TEMPORARY CONSTRUCTION ACCESS
FORD LANE, YAPTON, WEST SUSSEX

DESIGNER'S RESPONSE TO ROAD SAFETY AUDIT STAGE 1/2

Report No.: 18-344-14

Date: January 2021

Drawing Title
LEVELS AND DRAINAGE

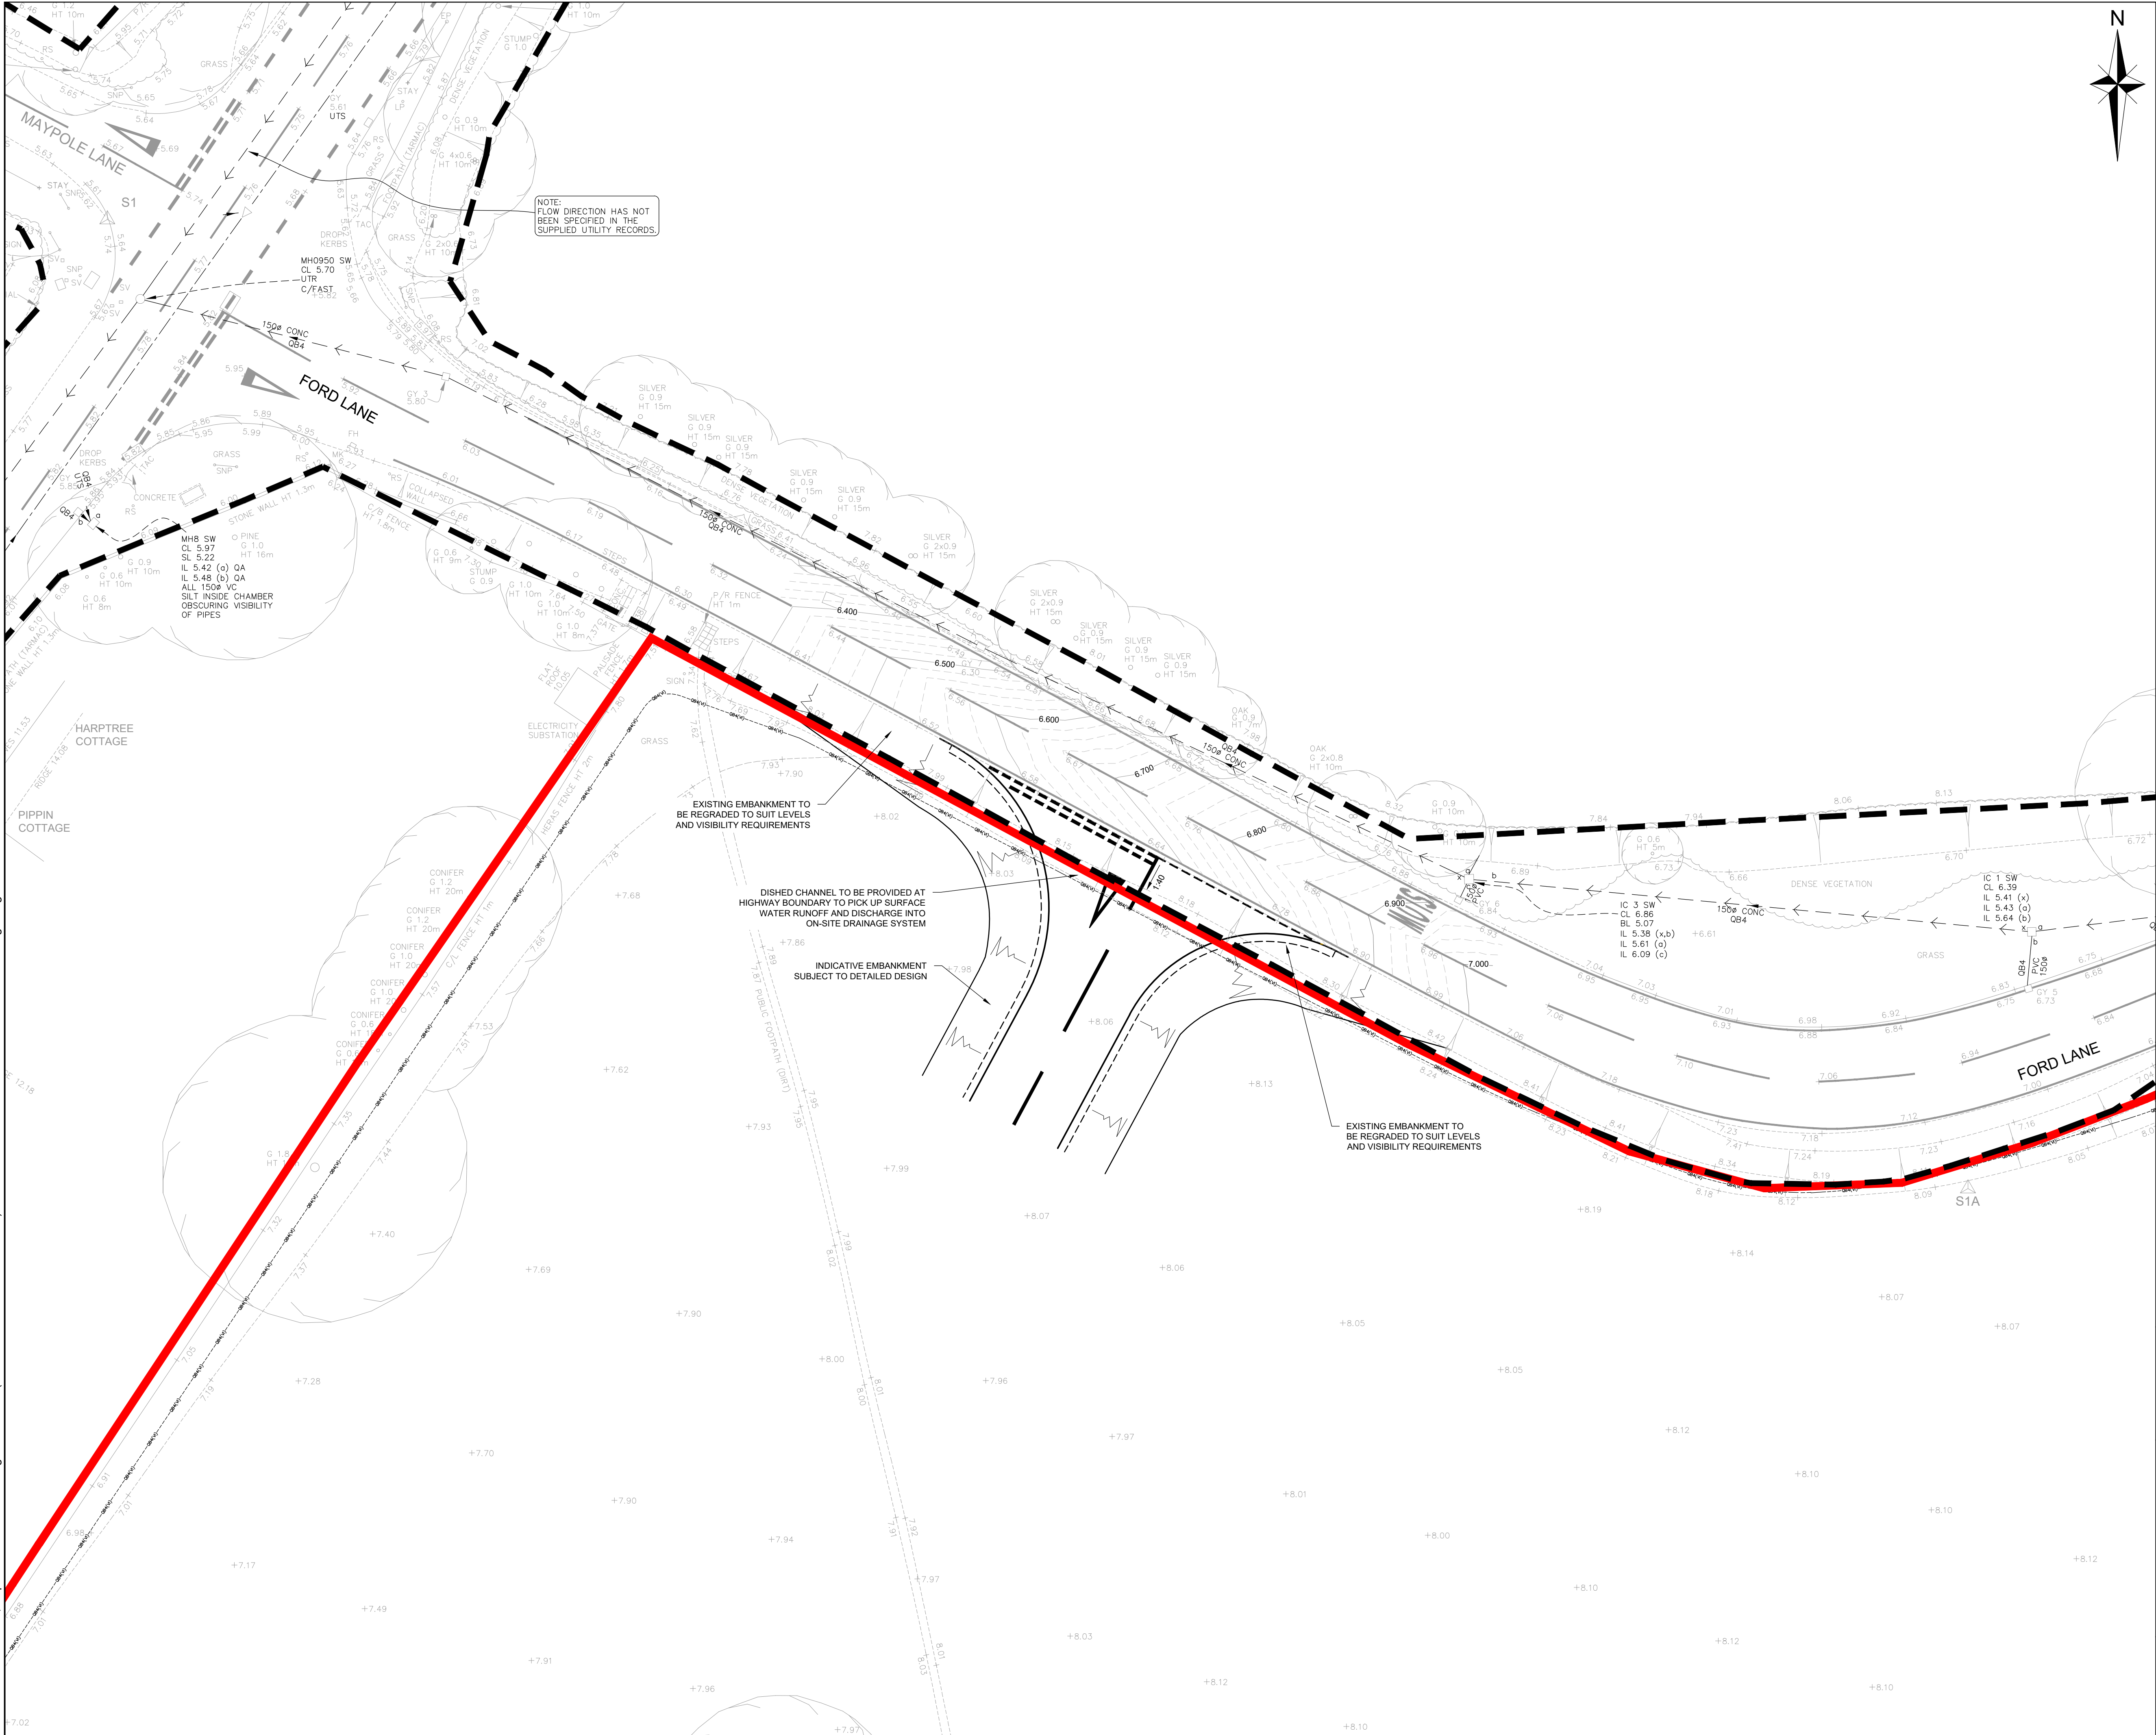
3.1	GENERAL				
3.1.1	PROBLEM Location: At the proposed access. Summary: Ponding of surface water could lead to loss of control collisions. Kerblines are being amended as part of these proposals, and the land slopes towards Ford Lane. No details have been provided regarding the proposed carriageway drainage, where inadequate drainage provision could cause possible ponding, which could lead to loss of control collisions.	It is recommended that drainage details and carriageway profiles should be such that surface water is shed to an appropriate surface water system.	Recommendation acknowledged. The proposed access levels have now been adjusted such that any localised surface water will drain towards the site access and into the on-site surface water system.

GENERAL ARRANGEMENT

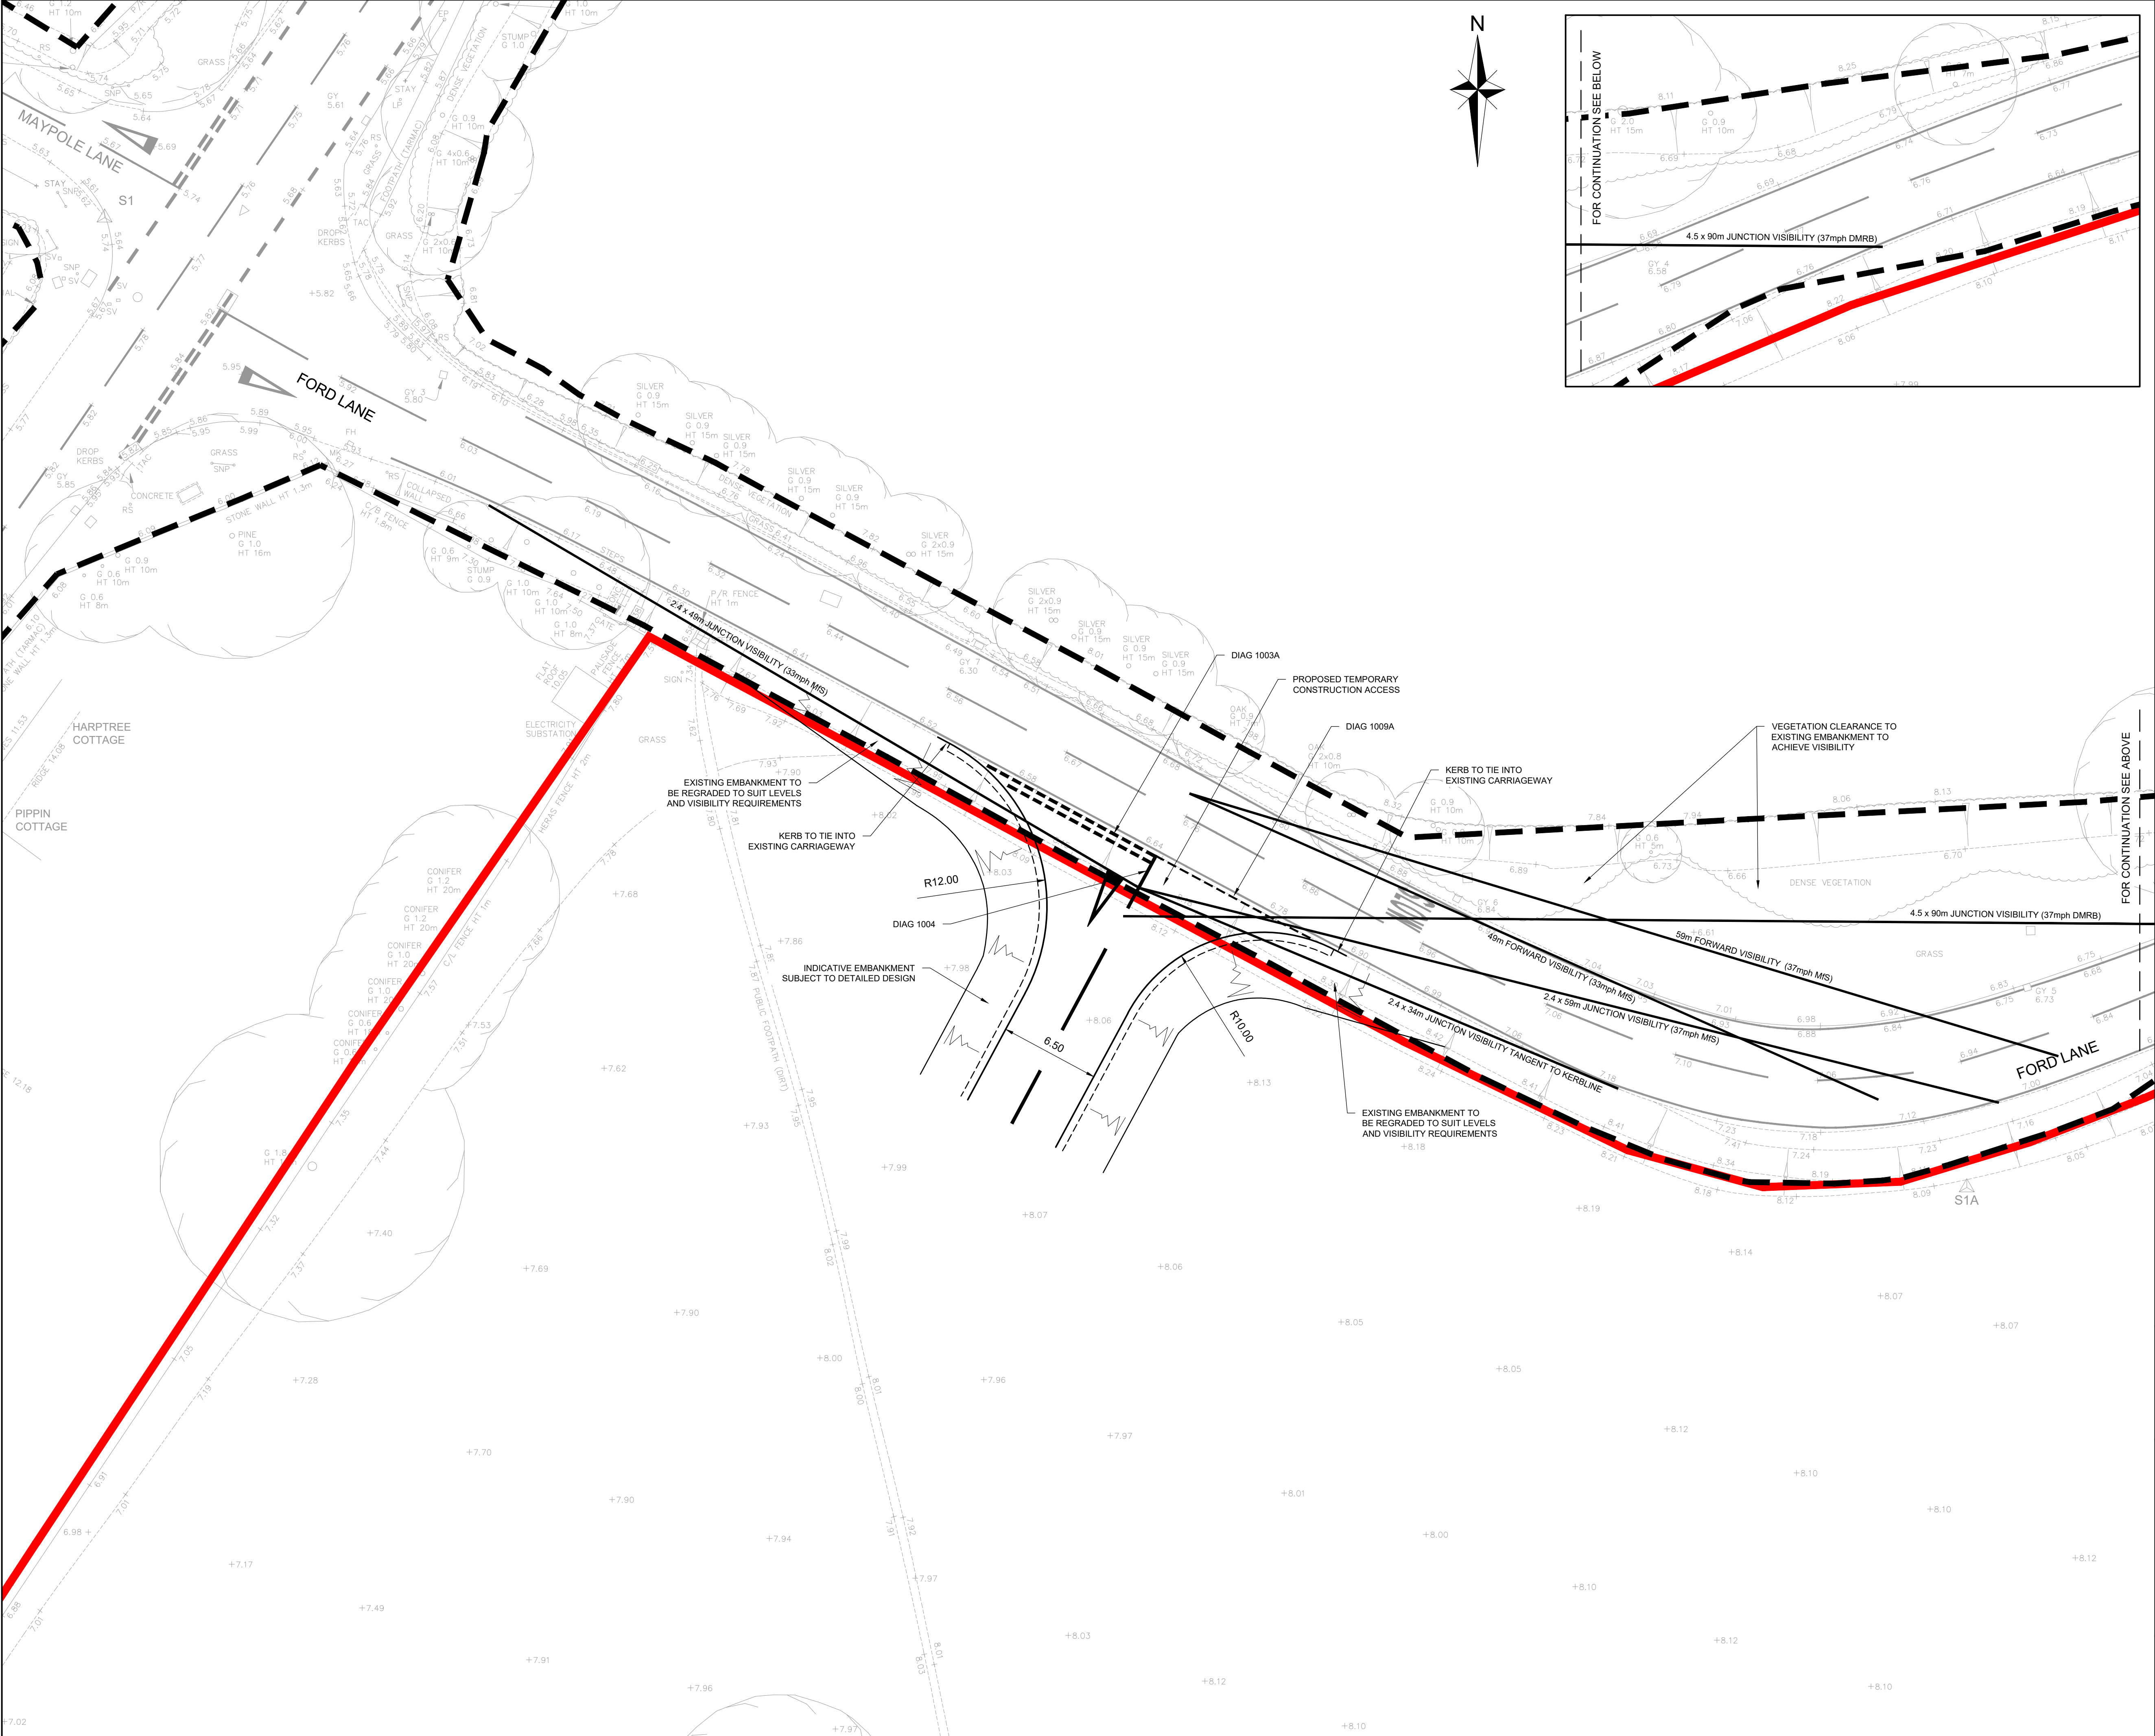
3.3	JUNCTIONS				
3.3.1	PROBLEM Location: At the proposed access. Summary: Insufficient visibility could lead rear end shunt head on or side impact collisions. Ford Lane is subject to National speed limit, visibility splays have been provided for 34m and 43m for the proposed access, which may be insufficient for the vehicle approach speeds. Further, no forward visibility splays have been provided for vehicles waiting to turn right into the proposed access	It is recommended that forward and junction visibility splays should be commensurate with traffic speeds. Further that forward visibility splays and traffic speeds should be provided for assessment.	Further traffic speed data has now been made available and visibility splays have been updated to reflect this. 85th percentile speeds were recorded at 37mph for westbound traffic and 33mph for eastbound traffic.

Audit Item No.	RSA Problem	RSA Recommendation	Design Organisation Response	Overseeing Organisation Response	Agreed RSA Action
	where visibility is restricted see figures 1 and 2 below.  Insufficient visibility splays and forward visibility splays could lead to rear end shunt head on or side impact collisions.  Figures 1 and 2: Restricted visibility.
